## WEST SUSSEX COUNTY COUNCIL CONSULTATION

<b>TO:</b>	Arun District Council FAO: Simon Davis
<b>FROM:</b>	WSCC – Highways Authority
<b>DATE:</b>	4 March 2025
<b>LOCATION:</b>	Land west of Pagham Road Pagham
<b>SUBJECT:</b>	<p>P/114/24/RES</p> <p>Reserved matters application (pursuant to outline permission P/178/21/OUT (APP/C3810/W/22/3302023)) for matters of appearance, landscaping, layout and scale concerning the construction of 95 new homes along with new pedestrian and cycle links, open space, landscaping, habitat creation, drainage features and associated groundworks and infrastructure. This development is in CIL zone 5 (CIL liable as new dwellings) and may affect the setting of listed buildings.</p> <p>Rang of Substitute Plans received.</p>
<b>DATE OF SITE VISIT:</b>	n/a
<b>RECOMMENDATION:</b>	No Objection

- Site Layout, drawing number SL.01 revision F
- Bargate Response to comments made by consultees, February 2025

Client Bargate Homes
 Job no. BARG230419
 Dwg no. SL.01
 Author CMI Checked -
 Status PLANNING Scale 1:500 at A1
 Client ref. Office Romsey

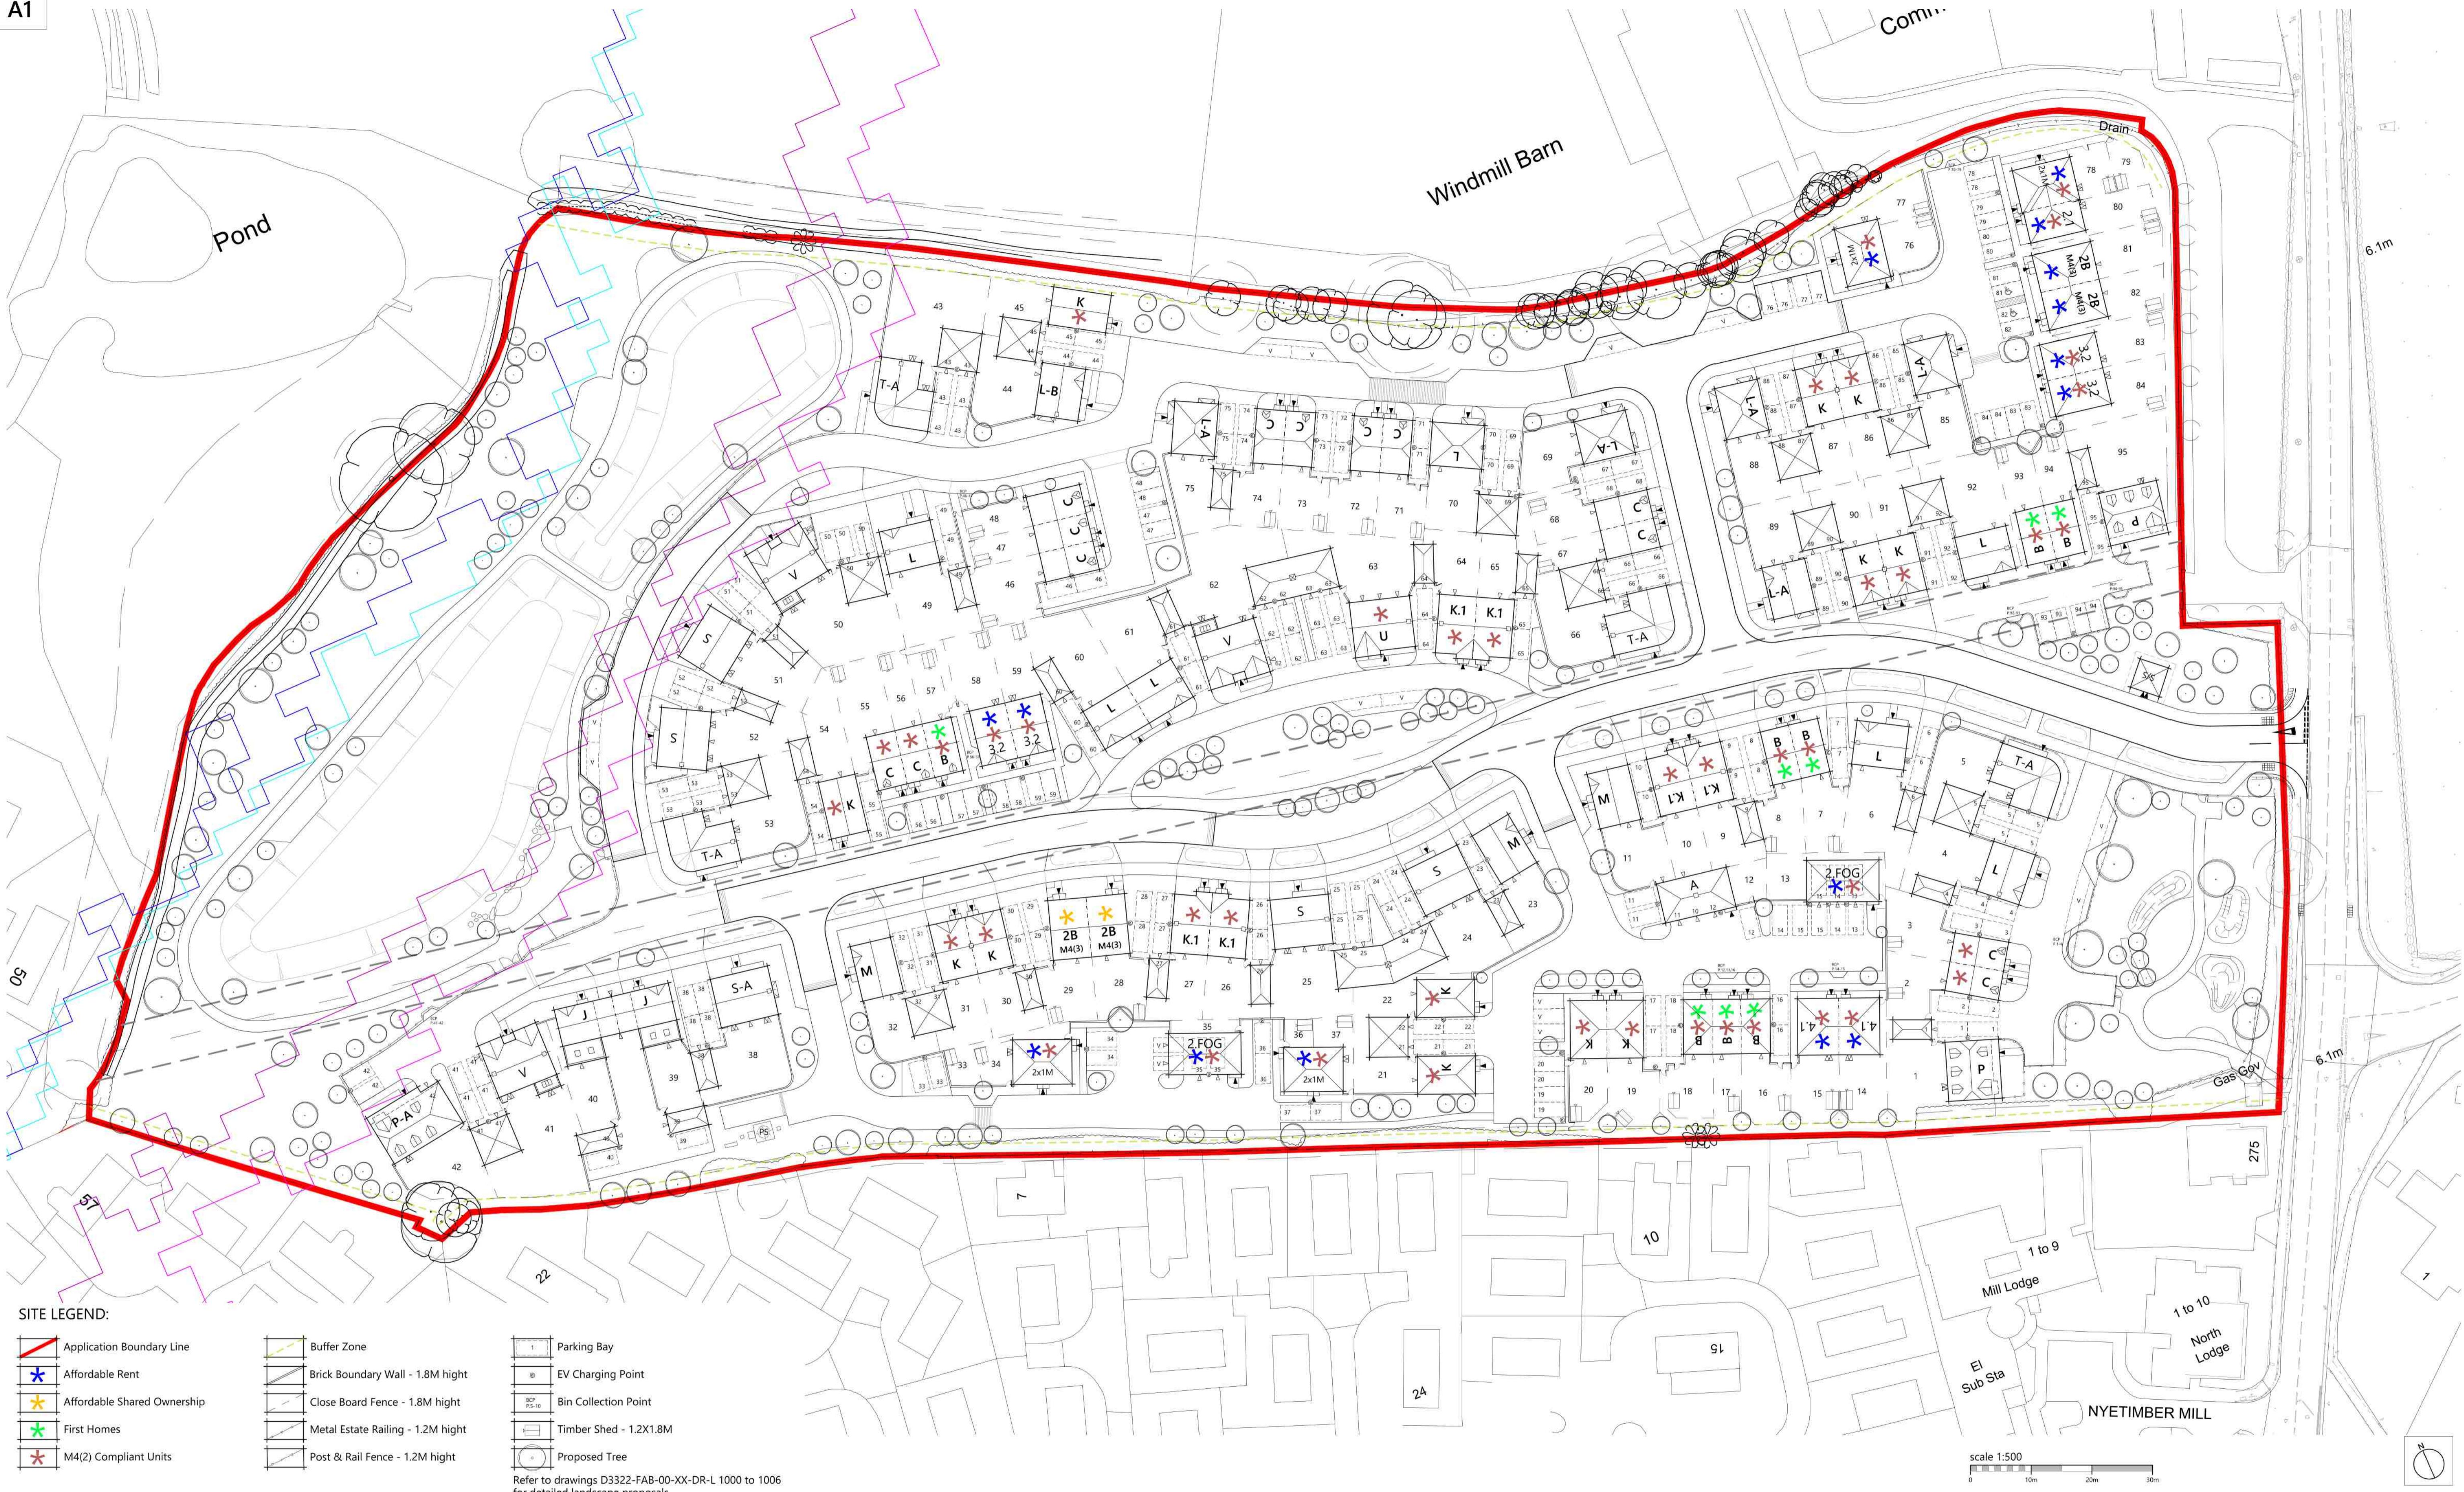
From the documents provided, it's apparent that the scheme has been updated to reflect the comments made by WSCC Highways. Whilst there are matters that haven't been revised; the carriageway alignment in front of plots 44-45 being the most apparent. The Applicant has still demonstrated that the arrangement in this situation is workable. Given the likely traffic flows, WSCC wouldn't anticipate that the arrangement would give rise to any unacceptable highway impacts.

A condition is recommended to secure details of tactile paving and dropped kerbs at pedestrian crossing points within the development.

No dwelling shall be first occupied until plans and detail showing the provision of dropped kerbs and tactile paving at all pedestrian crossing points within the development have

been submitted to and approved in writing by the Local Planning Authority. The details once approved shall thereafter be implemented in accordance with the approved details.  
Reason: In the interests of road safety and to ensure suitable pedestrian crossing facilities.
